**Development Application and Planning Proposal Review
NSW Planning Portal Concurrence and Referral**

Authority	Authority's Reference	Agency Concurrence and Referral	Authority Contact	Authority Notification	Submission Due	Submission Made
NSW Dept. of Planning, Housing & Infrastructure	SSD 85238209		Sian Holmes	27/02/2026	12/03/2026	27/02/2026

Address	Land Title
16-20 Old Castle Hill Road Castle Hill	Lots 10 & 11 DP 881332, Lot 20 DP 222257, Lot 1 DP 204335

Environmental Impact Statement for Mixed Use Development and Rezoning at 16-20 Old Castle Hill Road, Castle Hill. Construction of a mixed use development of: 371 dwellings (including 42 affordable dwellings for 15yrs); One retail tenancy; Six basement levels. Concurrent rezoning to include FSR to 12.31:1.

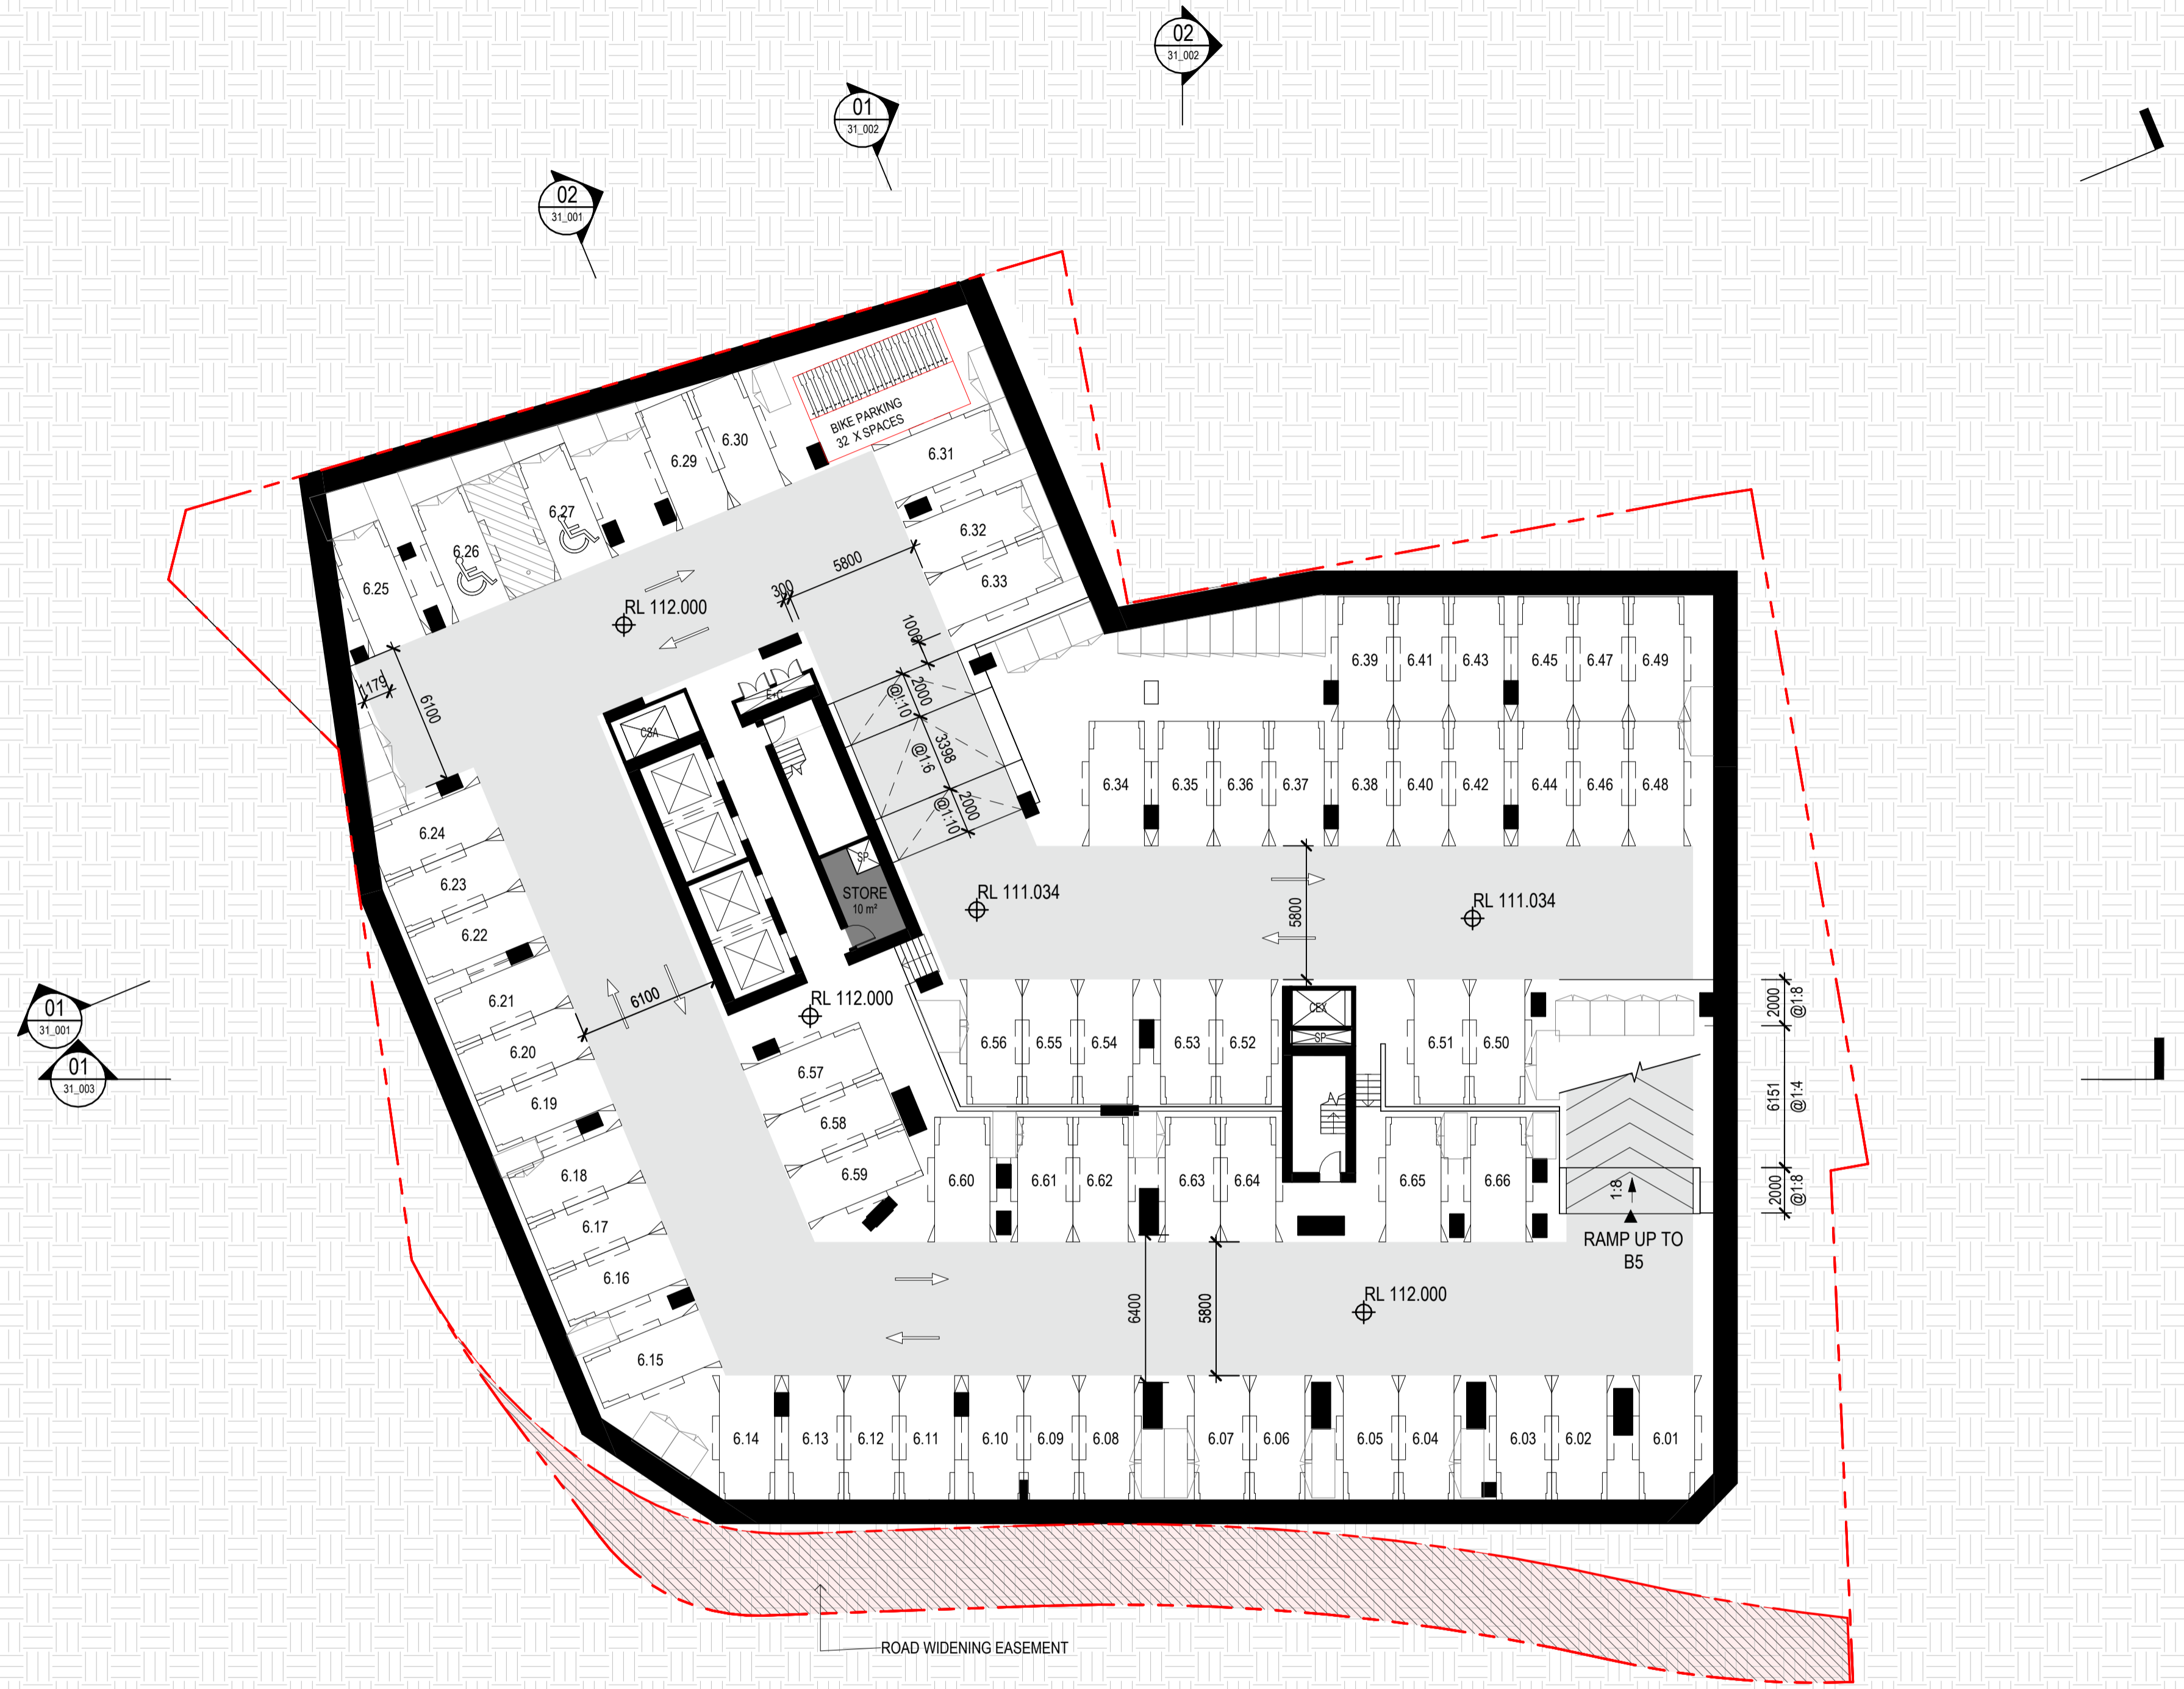
- Any required distribution substation/s will need to be located within the property (in a suitable and accessible location) and be protected (including any associated cabling not located within a public road / reserve) with an appropriate form of property tenure as detailed in the attached copy of Endeavour Energy's 'Land Interest Guidelines for Network Connection'.

Generally it is the Level 3 Accredited Service Provider's (ASP) responsibility (engaged by the developer) to make sure substation location and design complies with Endeavour Energy's standards the suitability of access, safety clearances, fire ratings, flooding etc. If the substation does not comply with Endeavour Energy's standards, the applicant must request a dispensation.

The EIS in Section '3.5 Uses and Activity' includes 'Substation' as a use on the Ground Floor. The below copy of the GA Plan - Ground Level shows provision of an indoor substation to the Garthowen Road frontage.
